Your Ref: OWPC6821
Our Ref: AW/163/15/HH 15-06-2015
Please ask for:
Mr D Vick

3 storey extension including moving living area to first floor level & 2 bedrooms with en-suite in the roof.

1 The Dunes Aldwick Bay

NEW NORTH ELEVATION

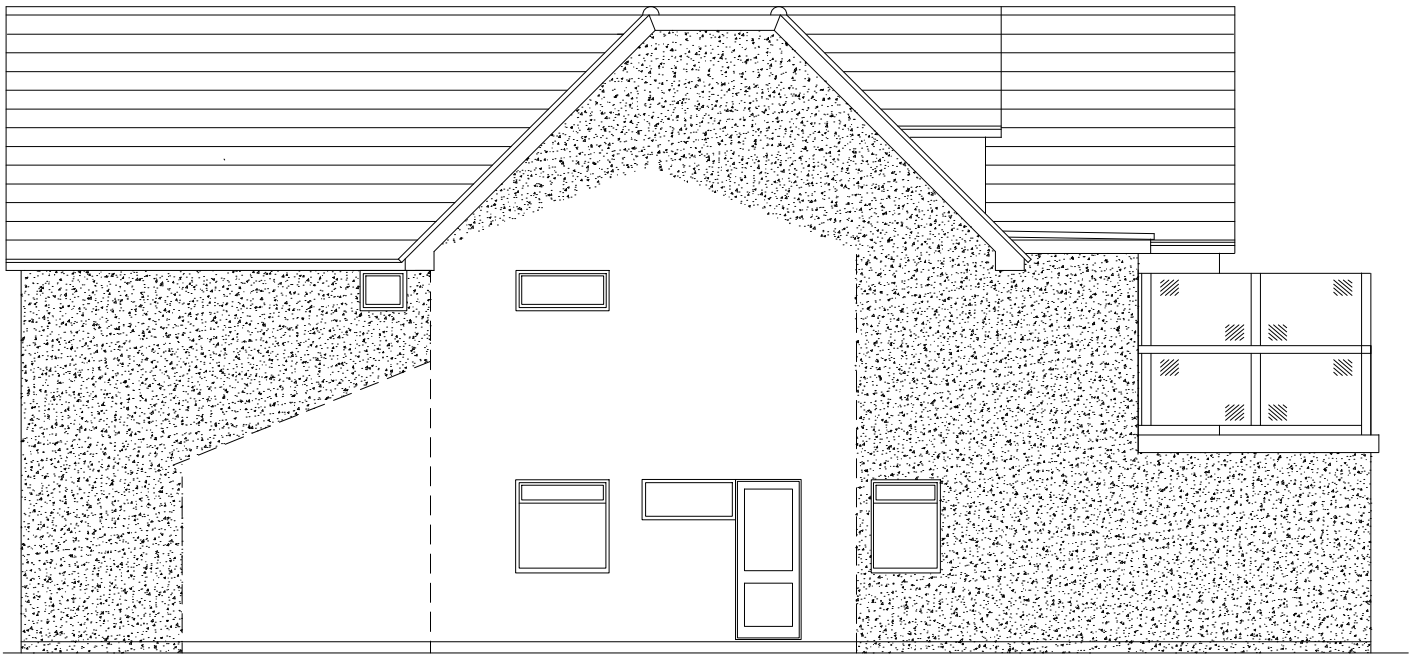
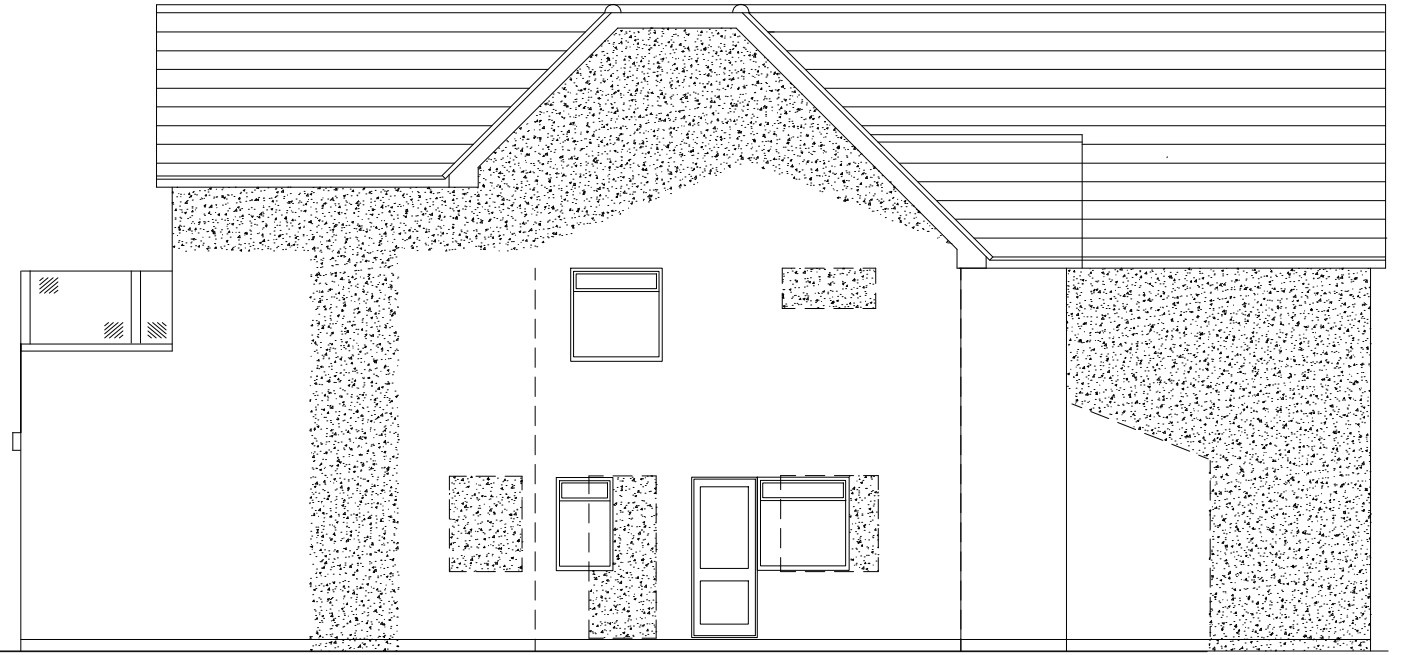
Looking at the plans and elevations it seems that it is proposed to have a Gabled roof whereas the other properties in the Dunes and indeed along the line of houses facing the beach all have hipped roof ends which much more suits the local architecture and provides better views and sight lines from properties to the rear of this line I feel that no 1 The Dunes should use a similar design
